**From:** Holly Duncan  
**Sent:** Tuesday, January 08, 2013 5:23 PM  
**To:** Jeff Watson  
**Subject:** RE: BL-12-00033 Tugwell

**From:** Jeff Watson  
**Sent:** Tuesday, January 08, 2013 2:22 PM  
**To:** Christina Wollman; Brenda Larsen; Jan Ollivier; Holly Duncan  
**Subject:** BL-12-00033 Tugwell

Tugwell Property  
 2400 Umptanum Road  
 509-962-2501

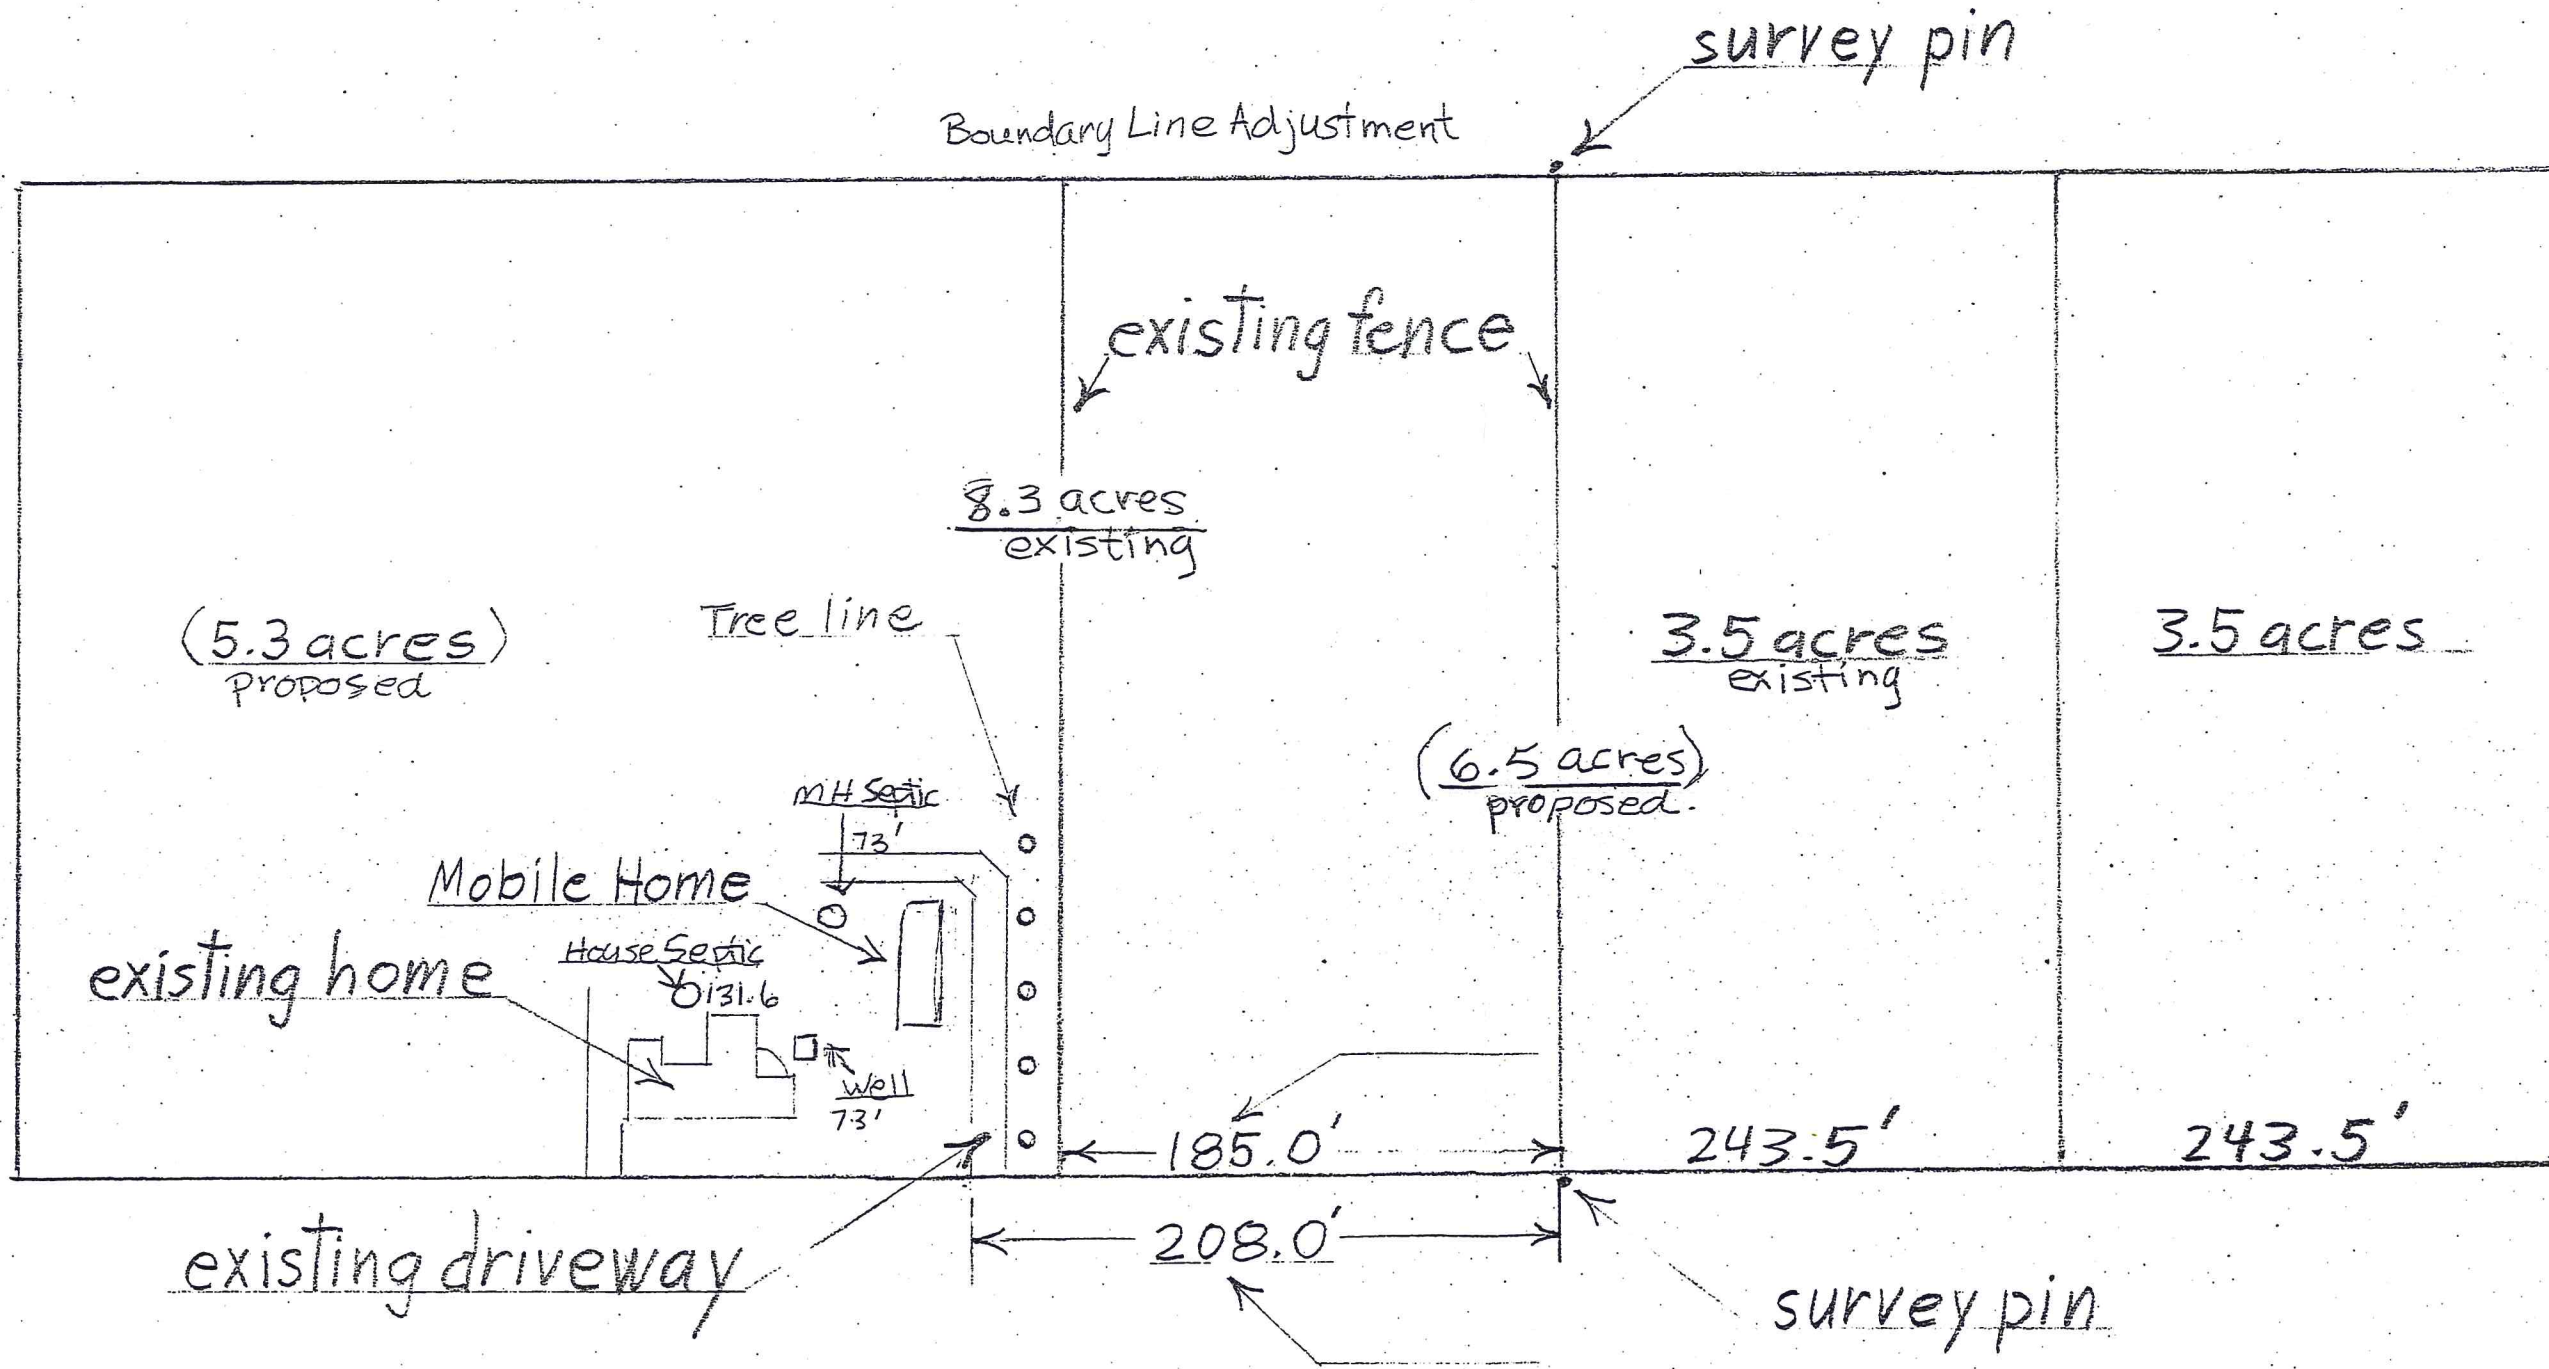
Looking at where the well and drain-field are located it appears that the new boundary lines shouldn't be a problem.
